WEST SUSSEX COUNTY COUNCIL CONSULTATION

TO:	Arun District Council FAO: Anita Gardner
FROM:	WSCC - Highways Authority
DATE:	20 December 2021
LOCATION:	Mistletoe Farm, Horsemere Green Lane, Climping, BN17 5QZ
SUBJECT:	CM/72/21/DOC Approval of details reserved by condition imposed under CM/18/21/PL relating to conditions 5-Biodiversity Enhancement plan, 7-covered and secure cycle storage, 8-electric vehicle charging space(s), 9-Energy Statement, 10-surface water drainage, 11-Arboricutural Assessment & 12-Construction Management Plan.
DATE OF SITE VISIT:	N/A
RECOMMENDATION:	Advice
S106 CONTRIBUTION TOTAL:	N/A

PROPOSED CYCLE STORE DETAILS
(1:50)

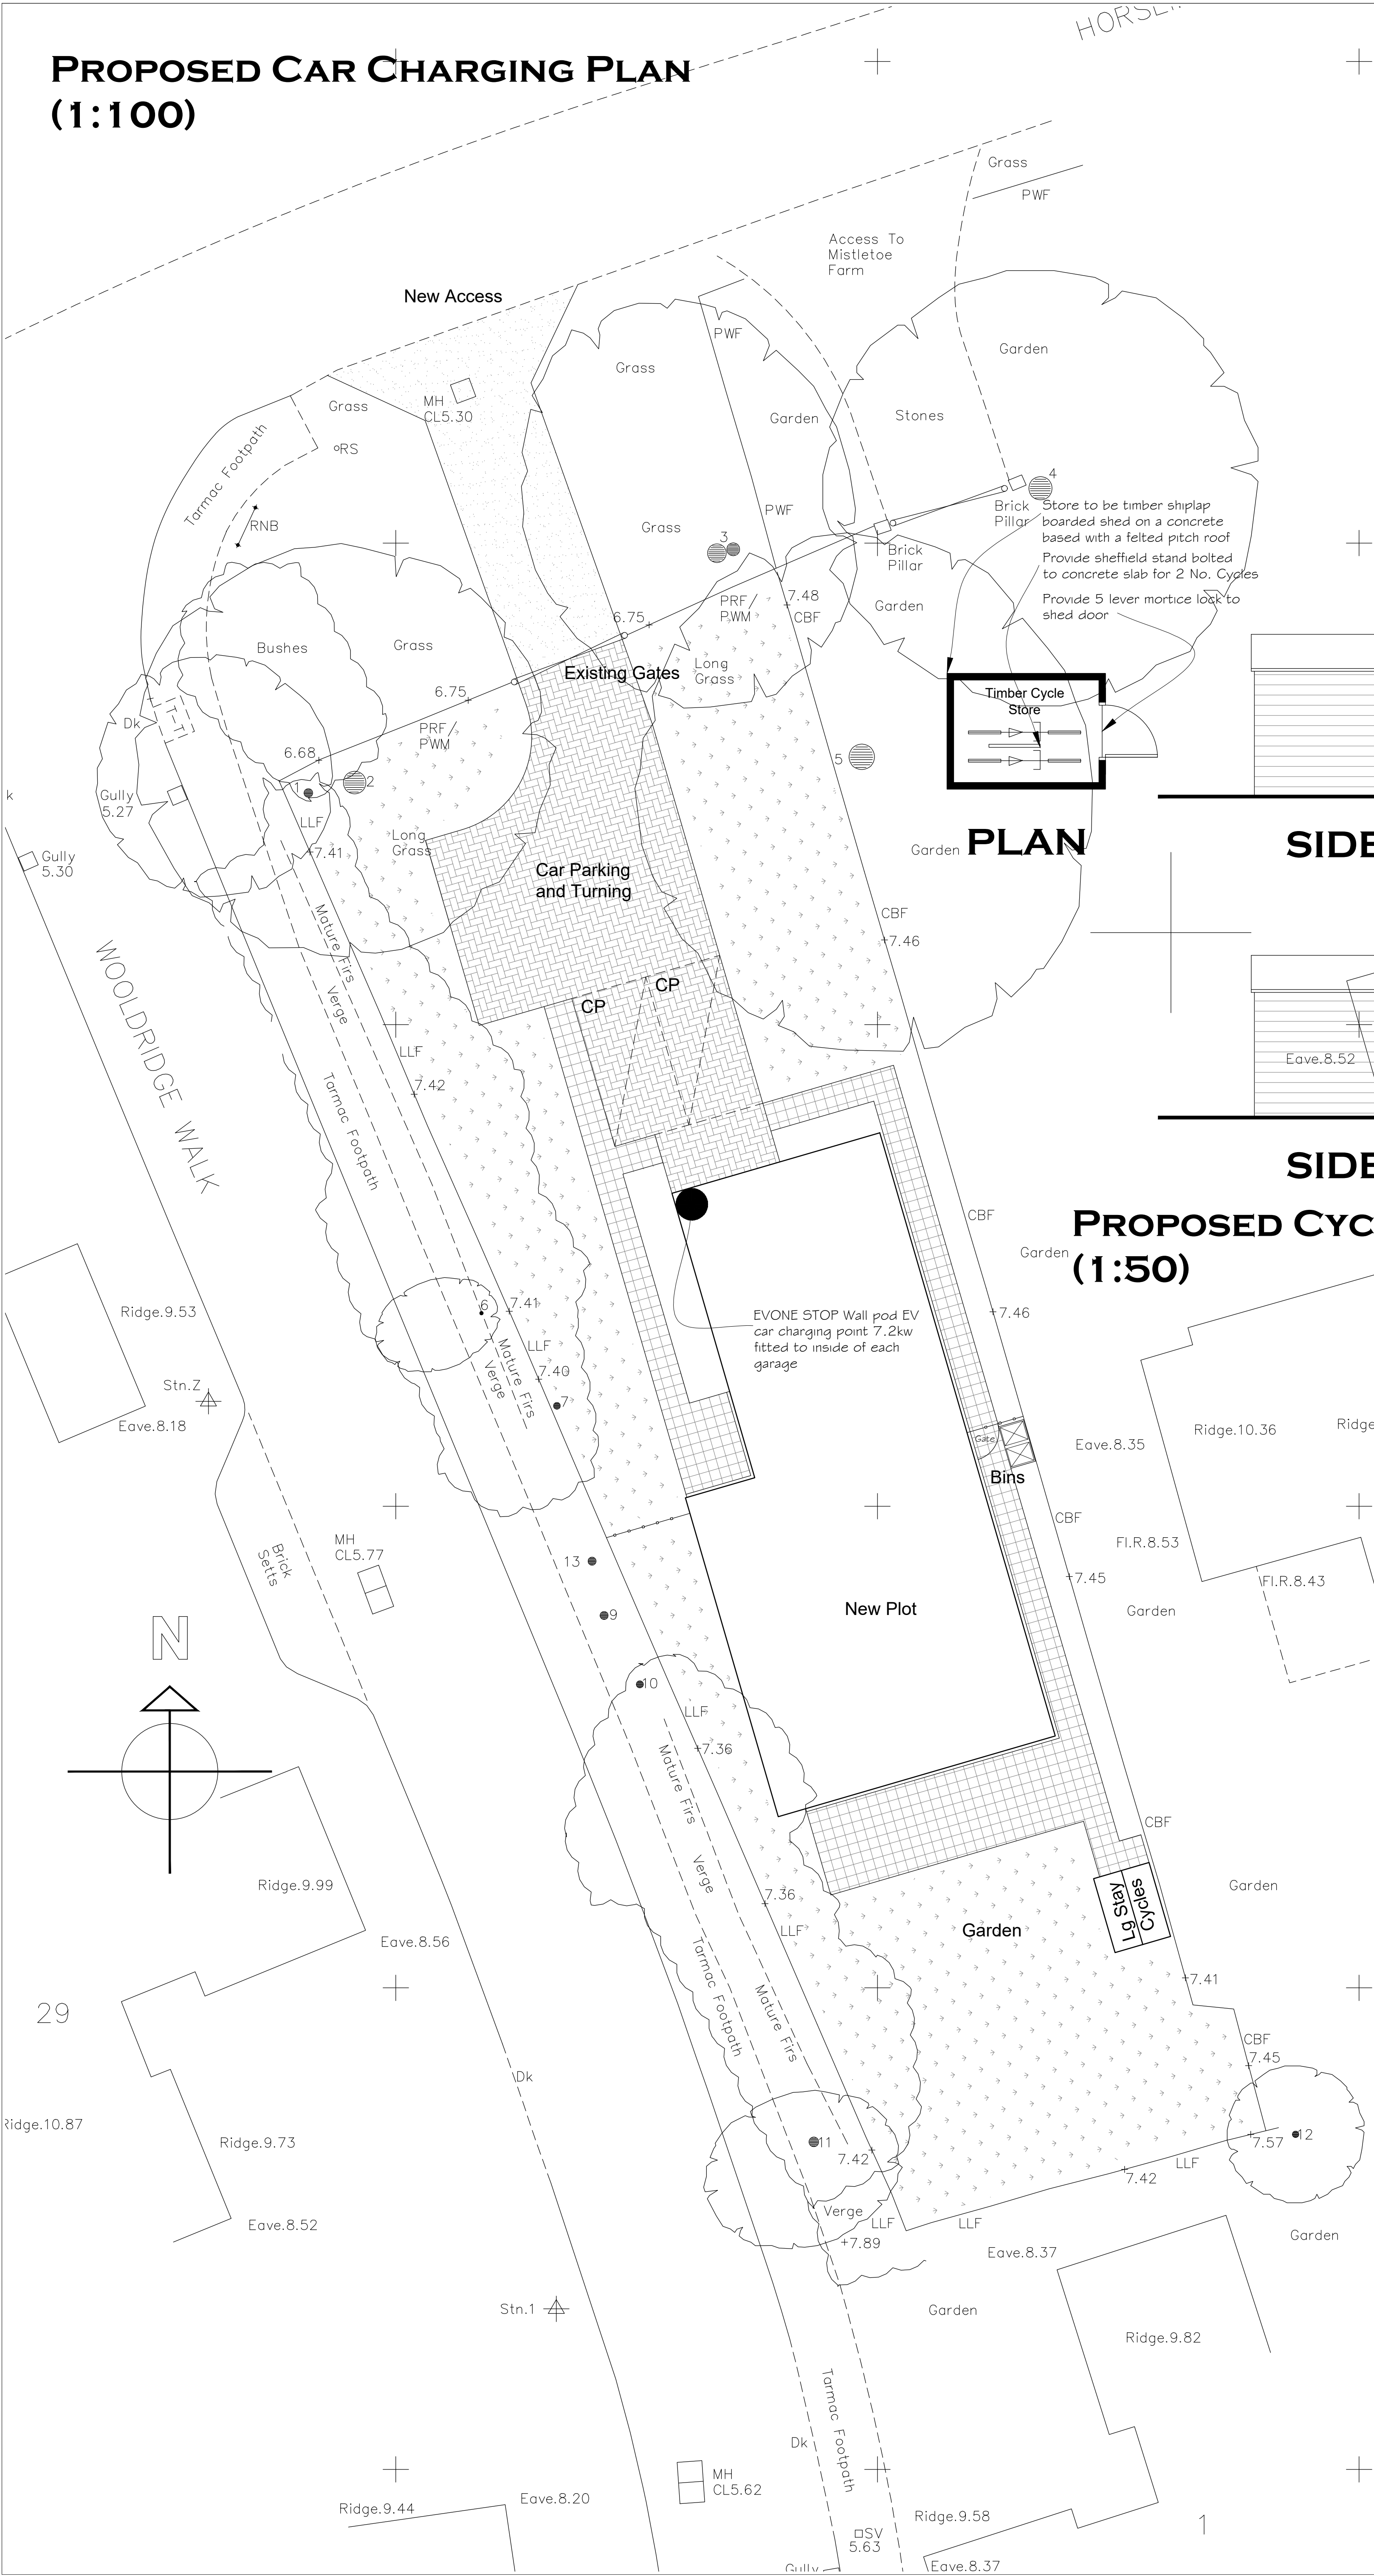
The applicant has provided details of the proposed cycle store, with provision for two cycles in accordance with Arun Parking Standards. The LHA is satisfied that Condition 7 can be discharged.

The applicant has provided details of the proposed EV parking provision, in accordance with Arun Parking Standards. The LHA is satisfied that Condition 8 can be discharged.
